# J.J. MARINO & ASSOCIATES

**RE: DWYER'S REDEVELOPMENT  
CROWN STREET, WOLLONGONG  
PRELIMINARY DESIGN PHILOSOPHY**

At your request, we have reviewed the architectural concept plans for the purpose of assessing whether a feasible structural scheme can be designed and constructed for the proposed development.

BASEMENT LEVEL 3
SCALE: 1:20

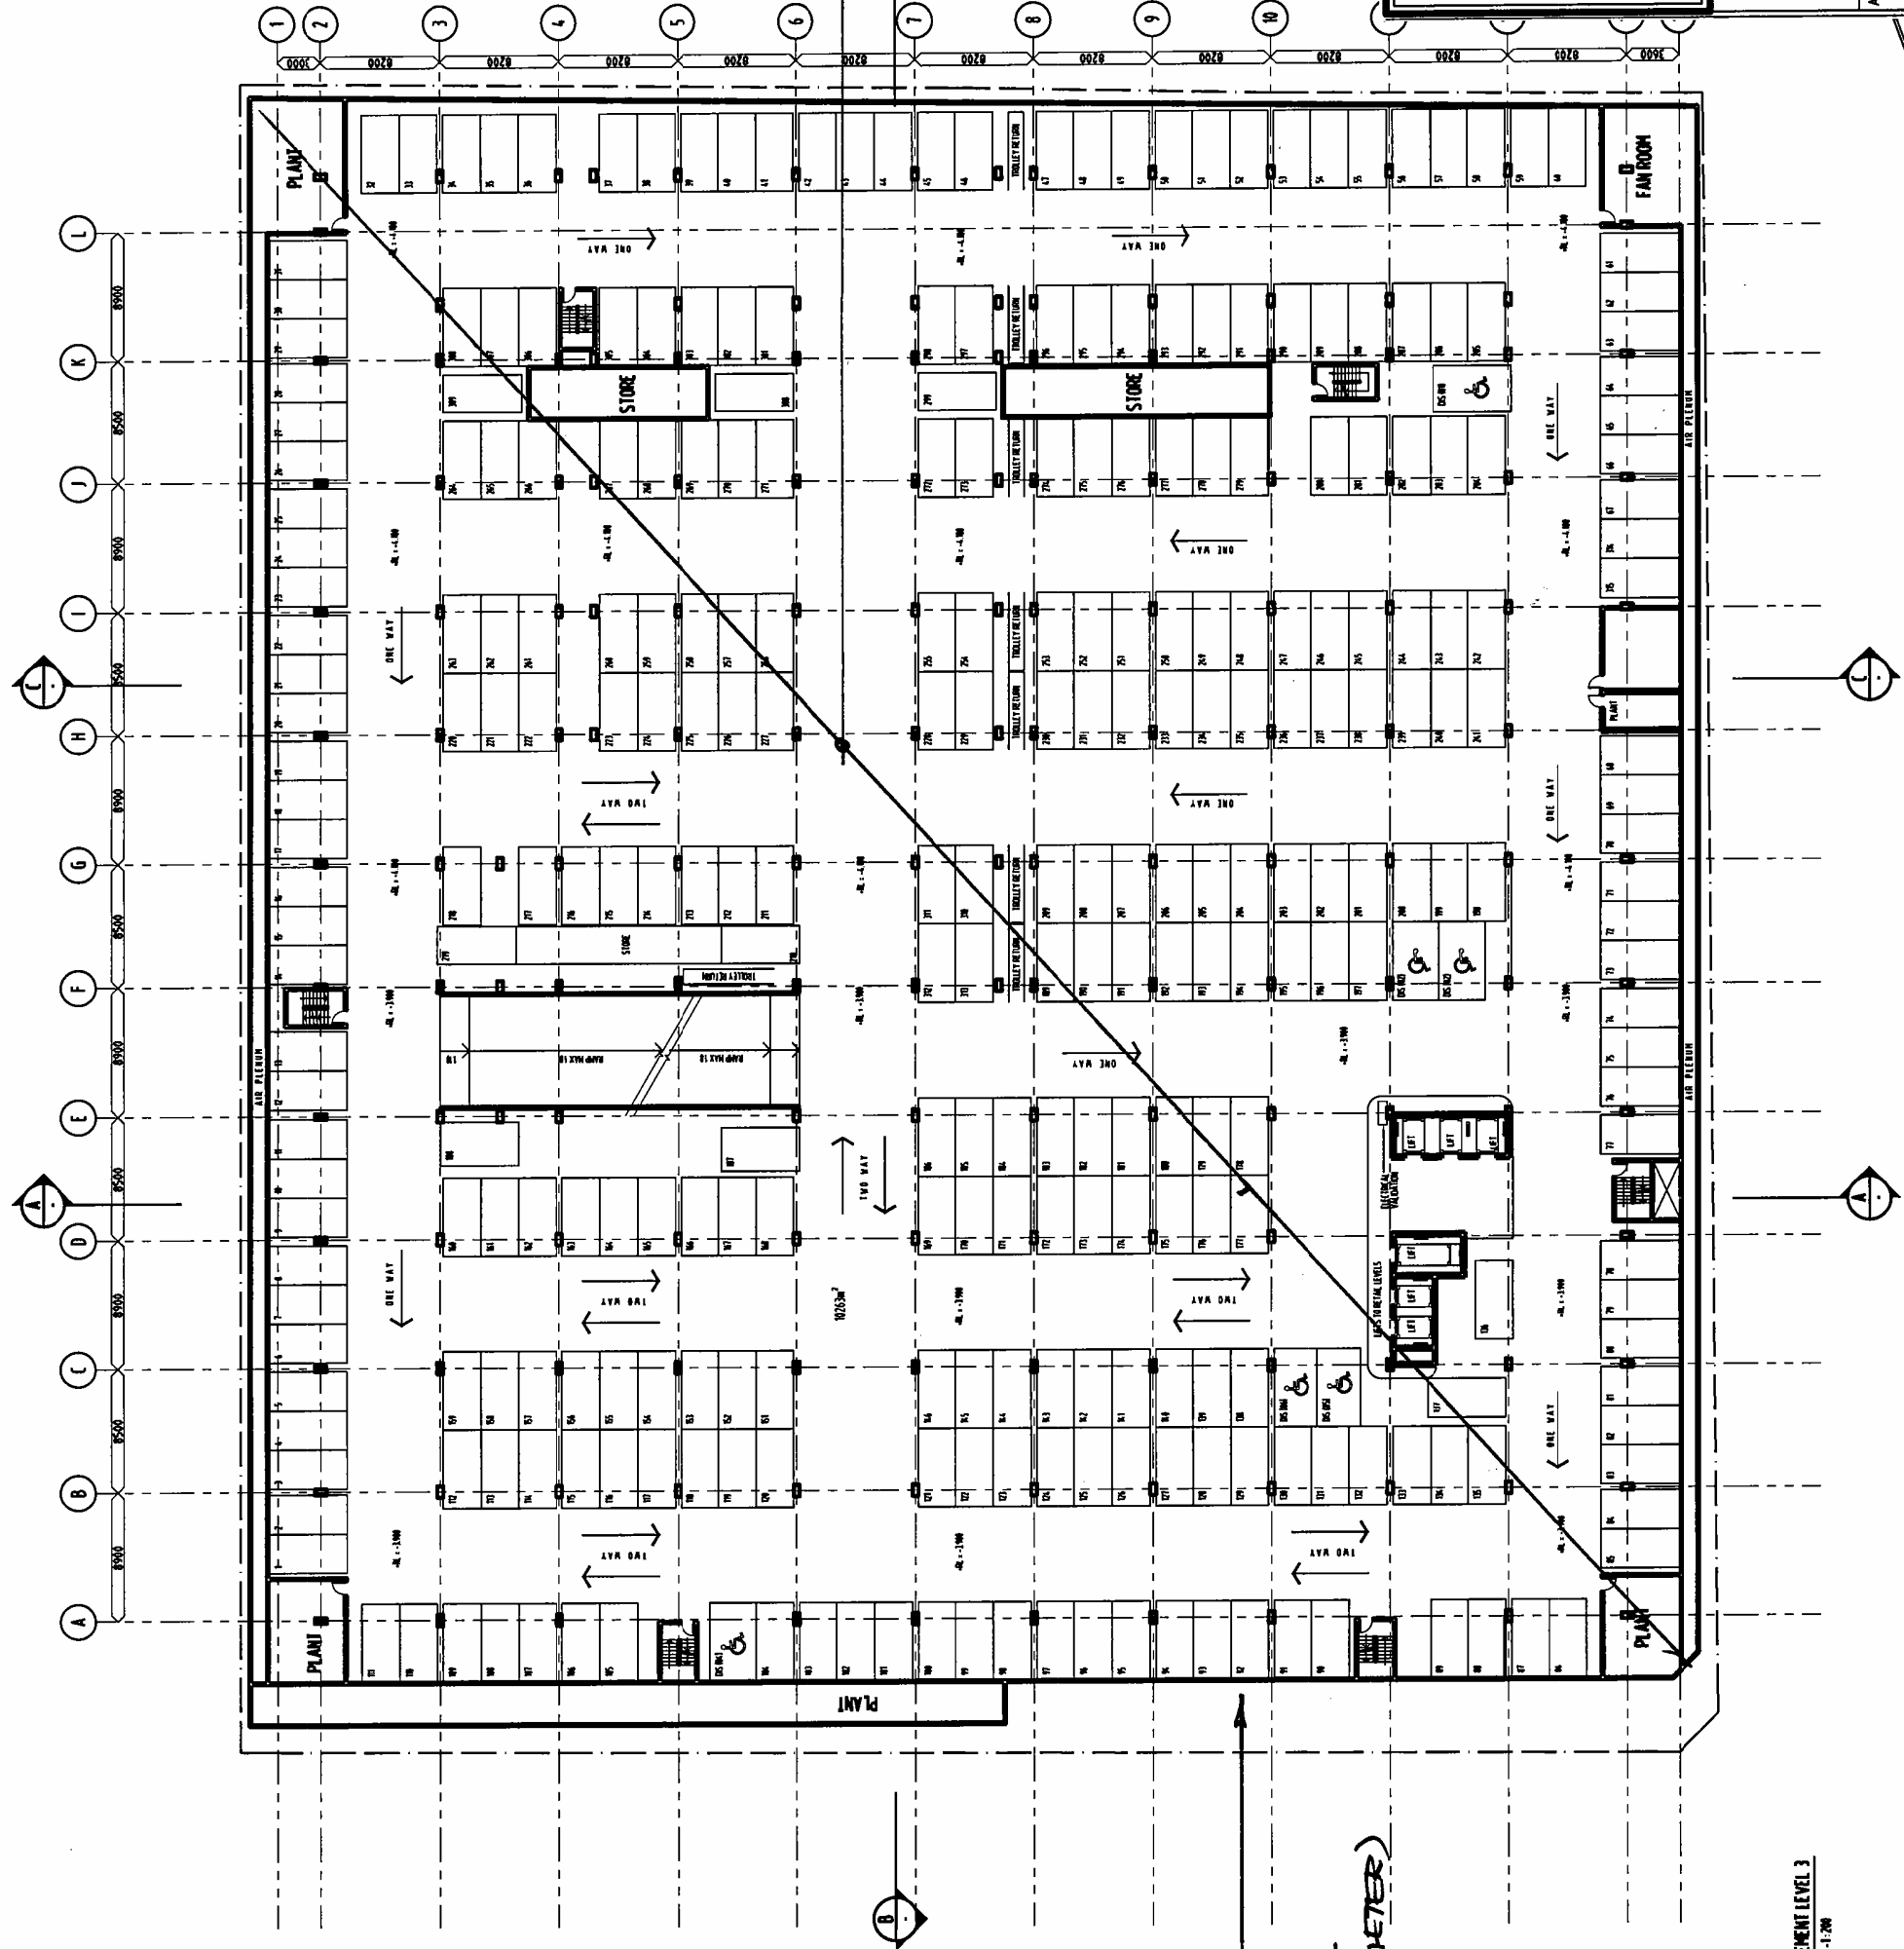
- Basement levels allowed for normal carparking loads with no "heavy" vehicles allowed.
- A 600 wide zone should be allowed for along the entire perimeter of the basement levels to accommodate a shoring wall system.

MINI MAJOR
• 400 THK STRUCTURAL ZONE.
• 600THK ZONE UNDER LIFT SHAFT. (TRANSFER ZONE)

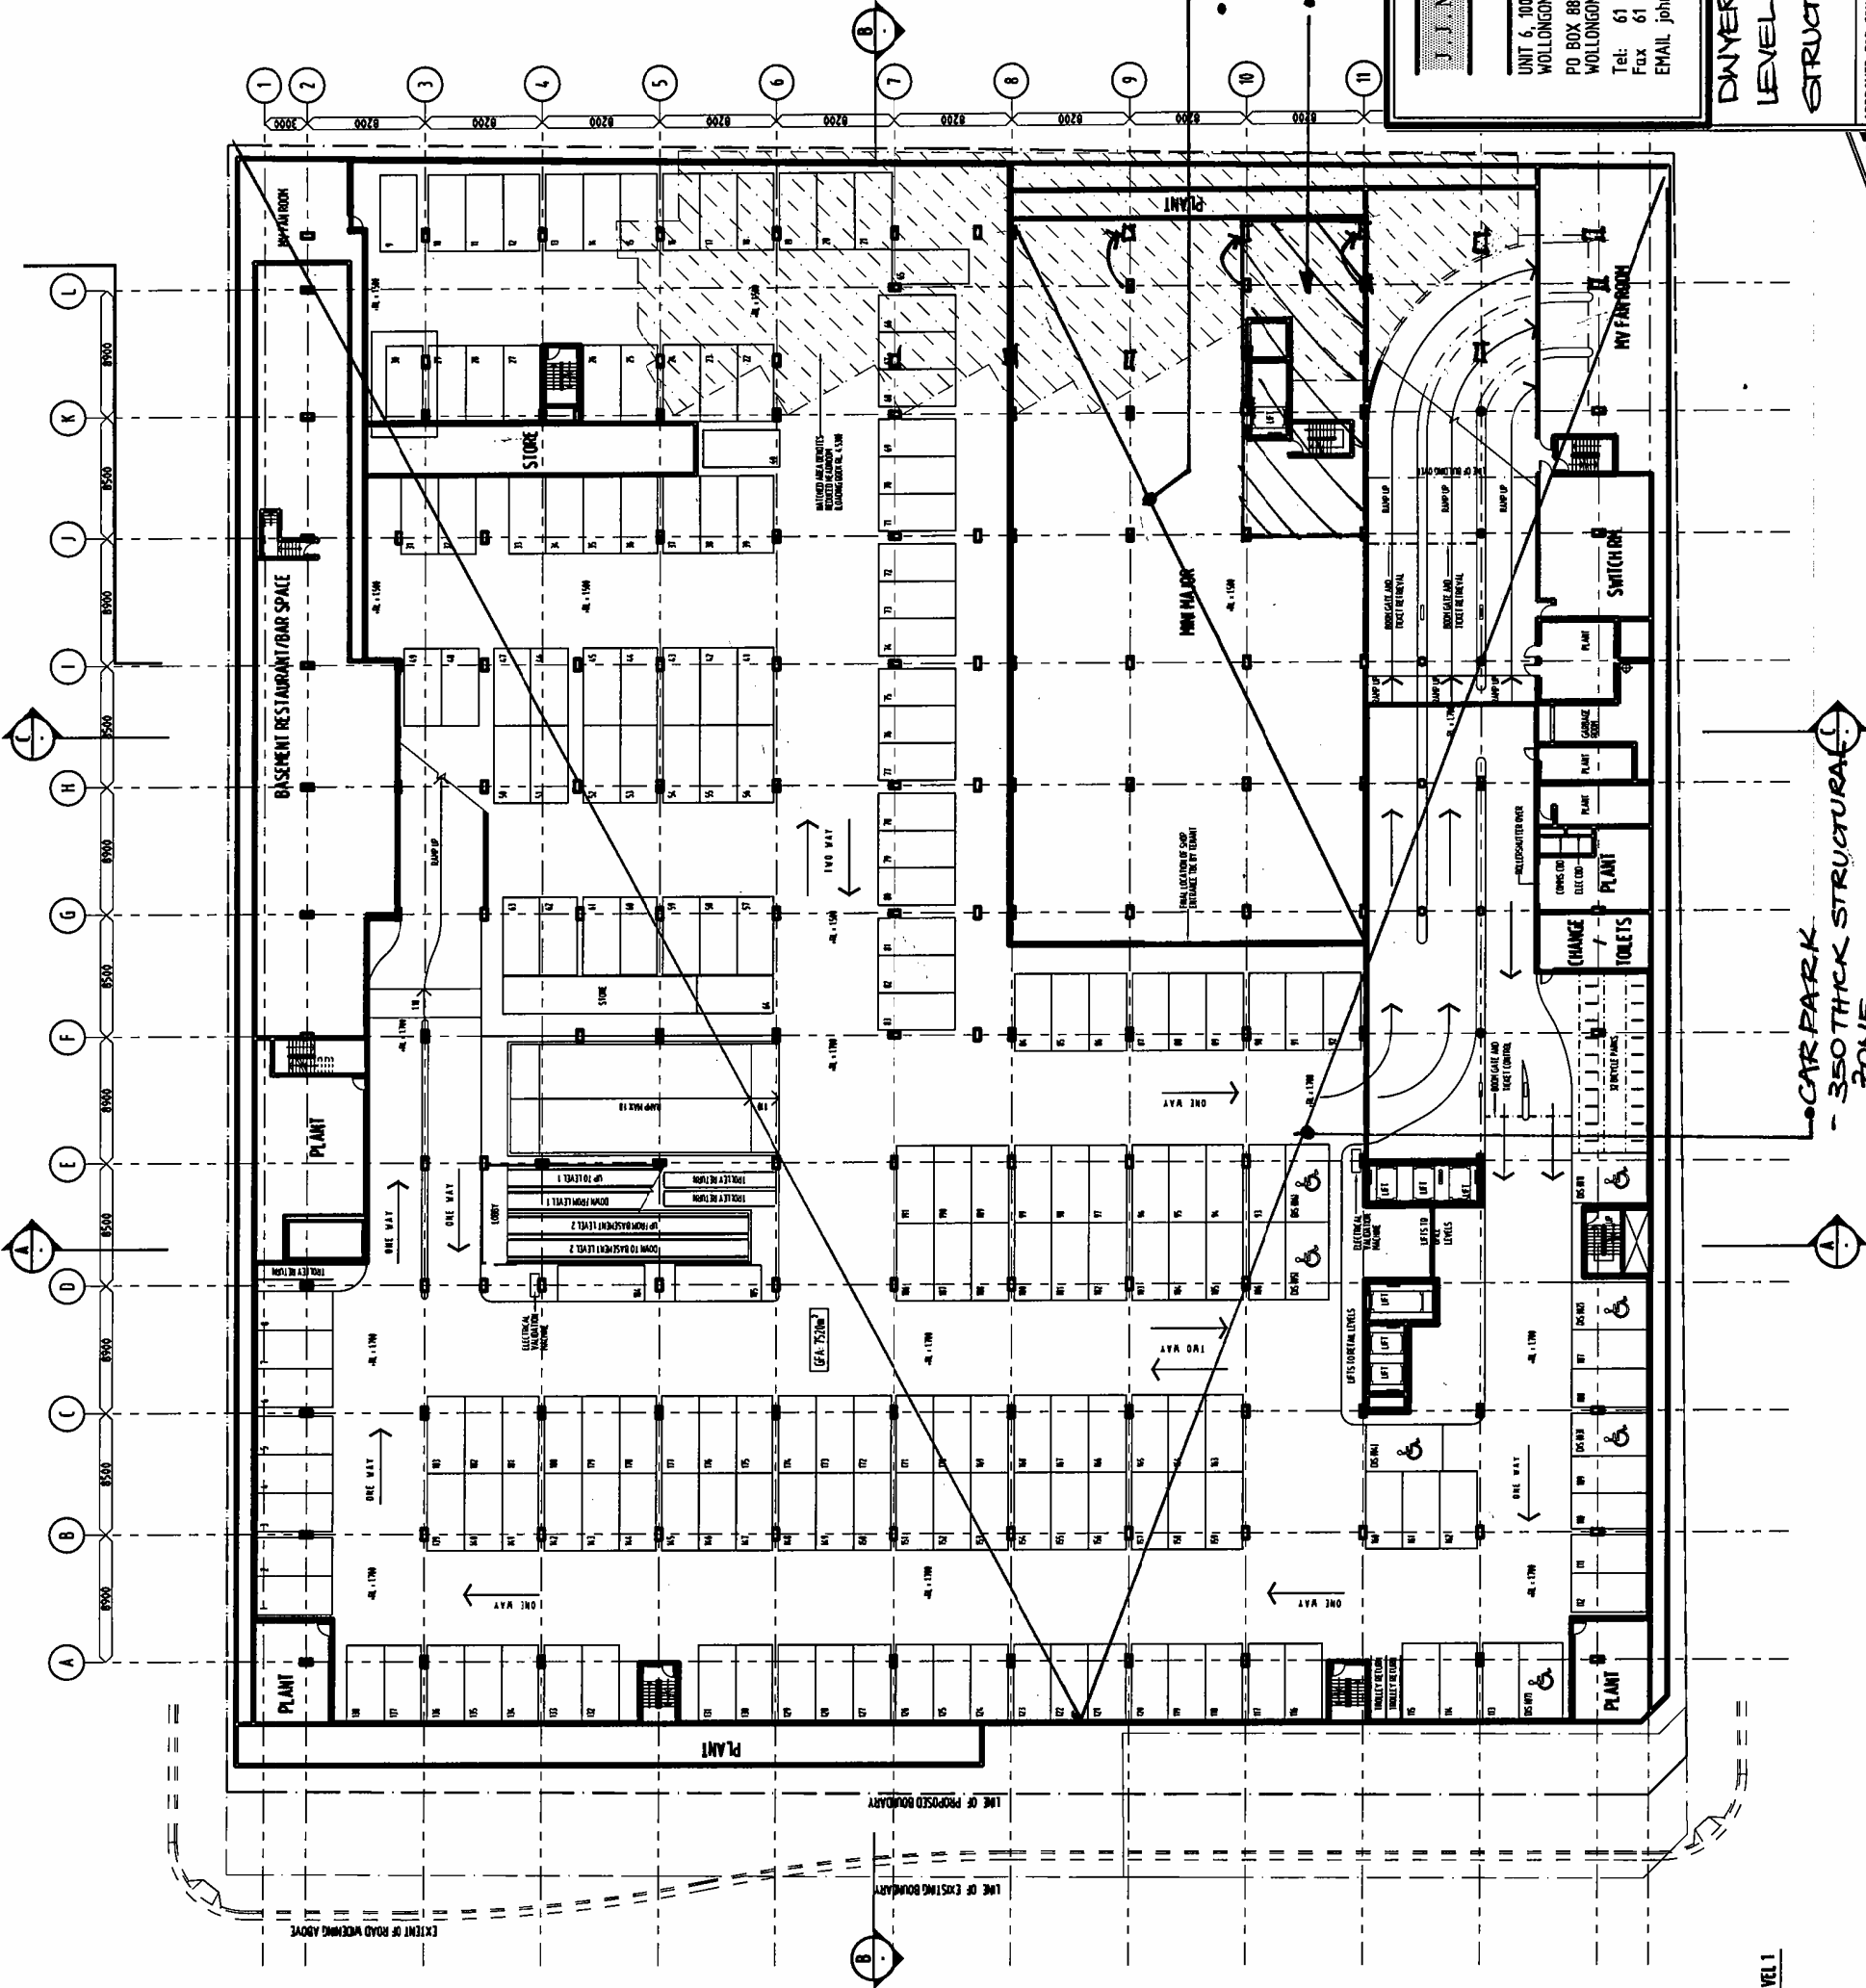
- 1500 deep transfer beams over loading dock area, spanning approximately 17m to support columns over and storage loads on Level 2.
- Lifts on Grid 10/K commence at Level 1 with lift pits etc extending to Level 1 Basement. 600 thick transfer zone allowed for locally to support the lift shaft walls.

APPROVED FOR CONSTRUCTION	SCALE	DESIGNED	ISSUE
DWYERS	08.07	DWYERS	DWYERS
DRAWN			
JOB No.	DRAWING No.		
07-104	DWYERS/SK8

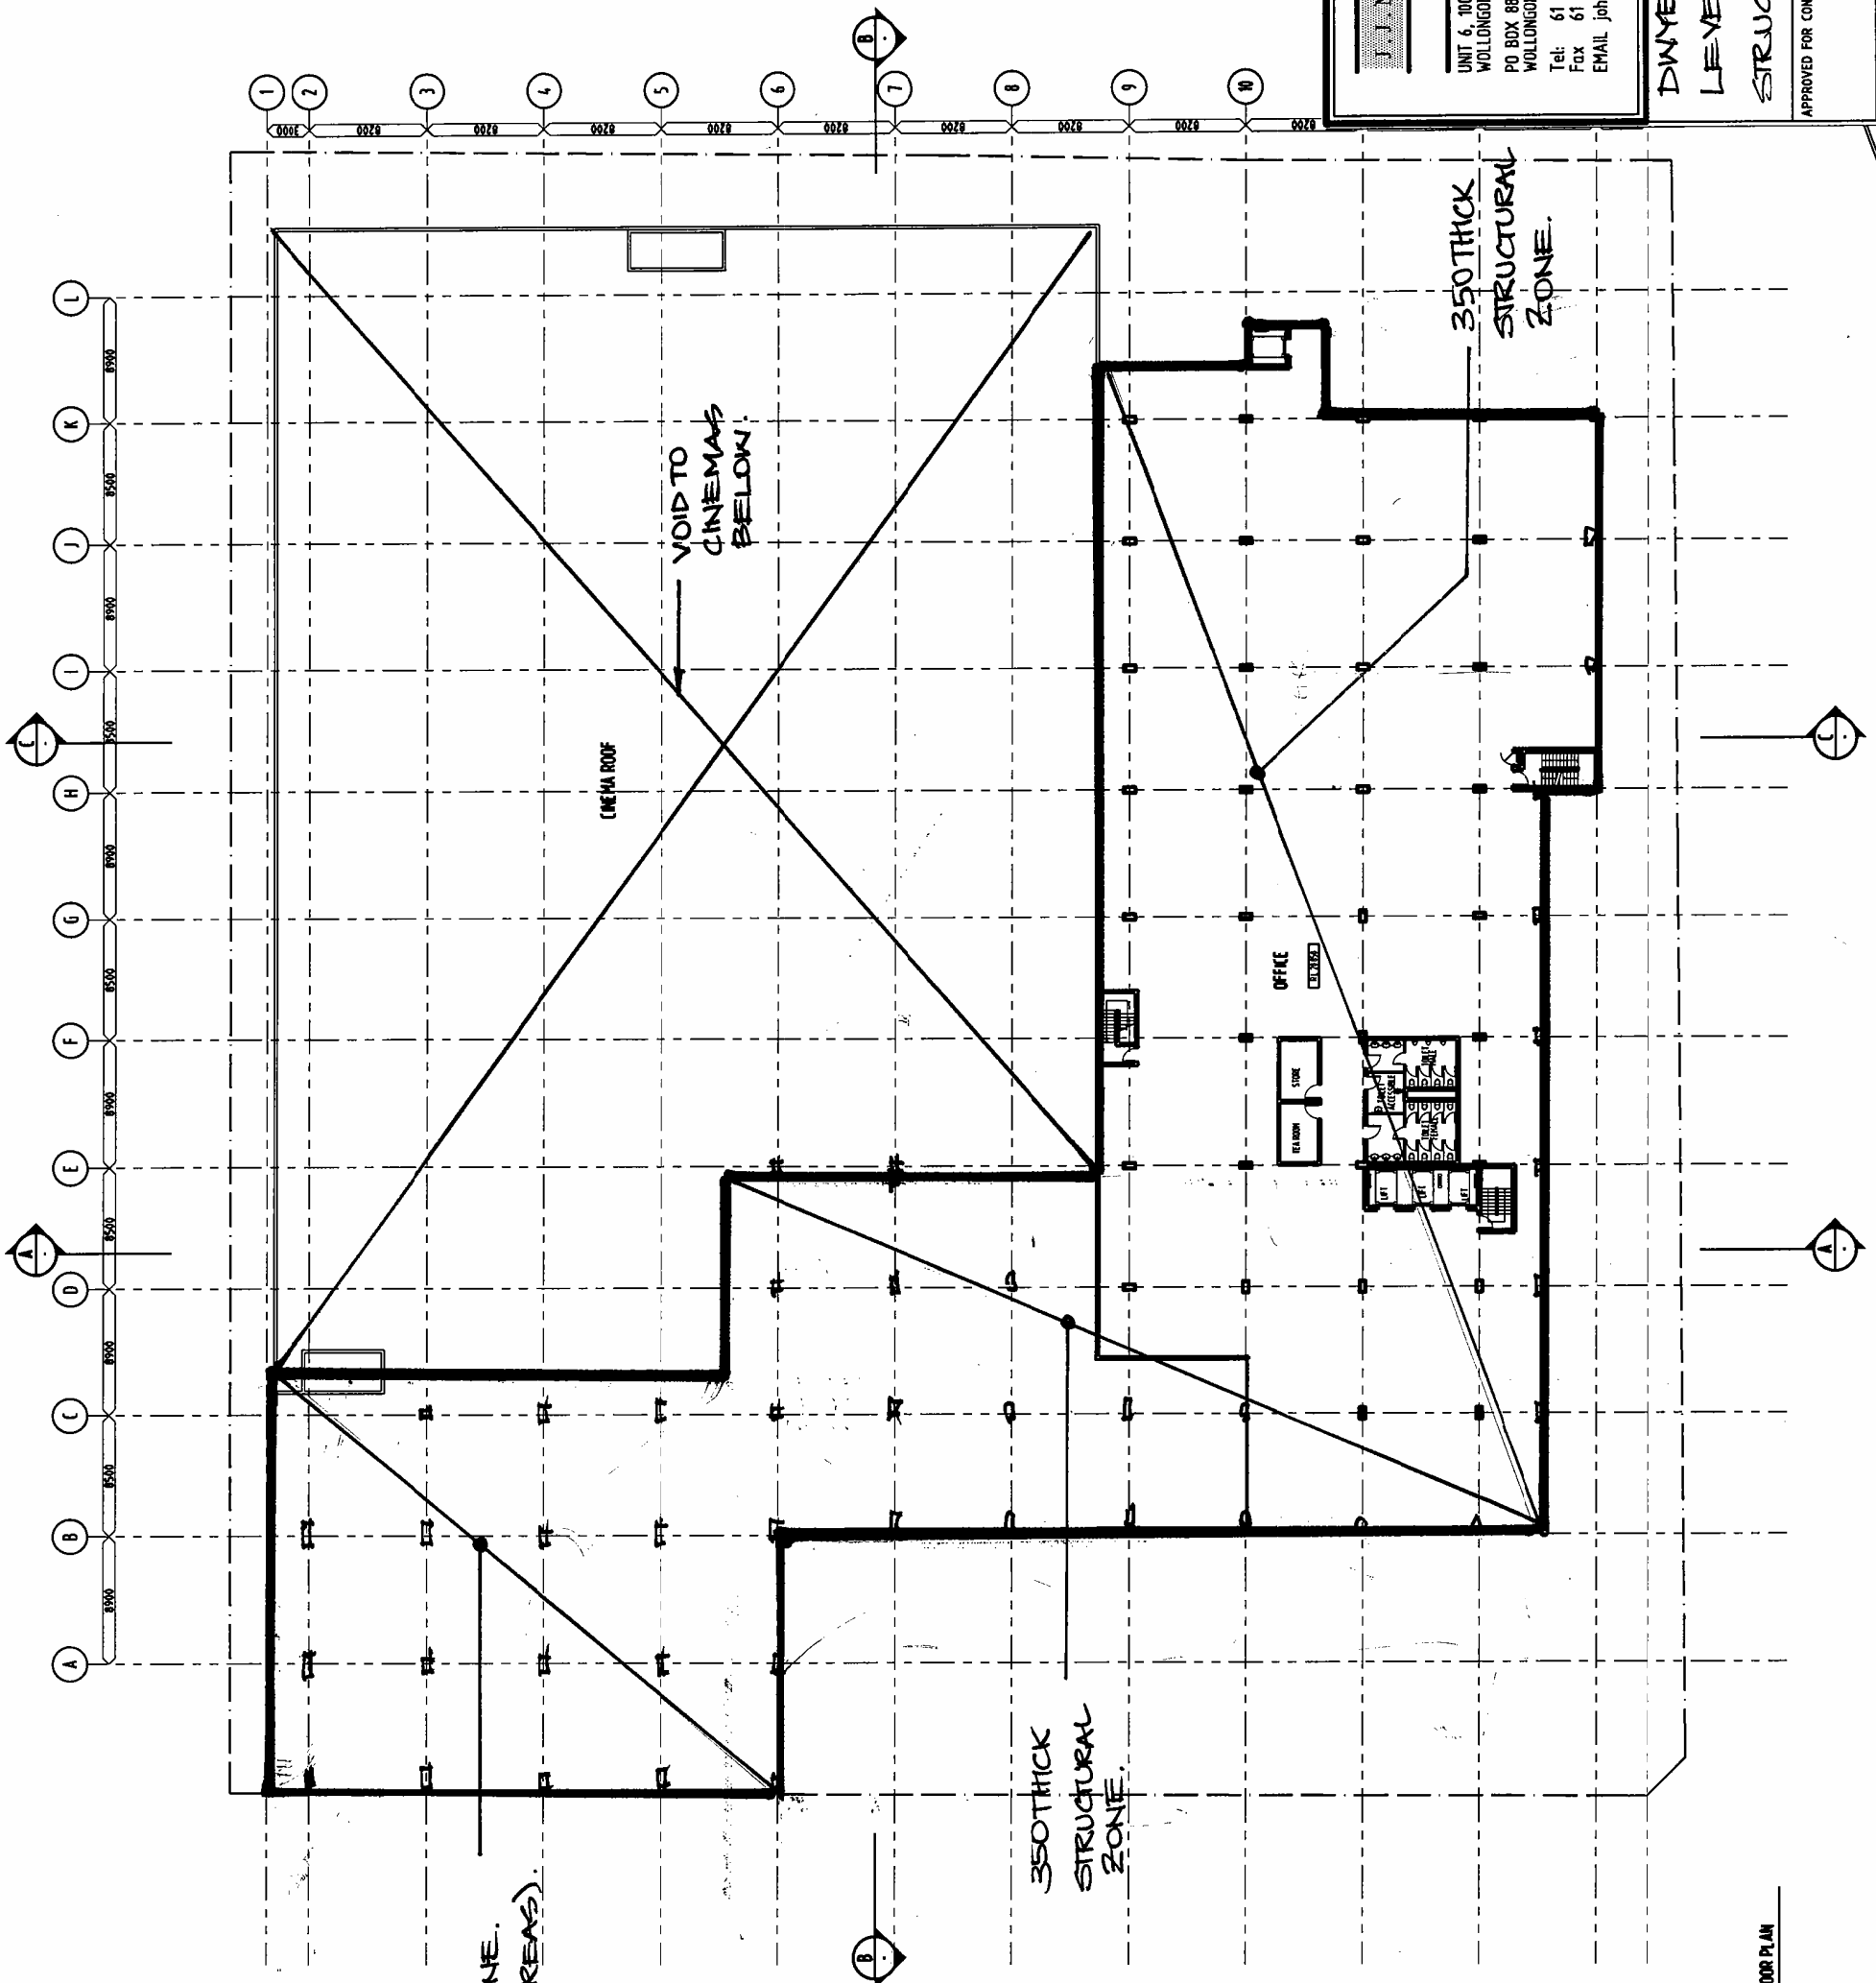
- Indicative locations of columns under (and over in transfer situations) are noted on the sketches.
- Level 5 extends to cover the footprint of the residential tower noted as part of Stage 2 of the development. This level is dedicated to commercial / office use. There is no concrete slab over the cinemas at this level.
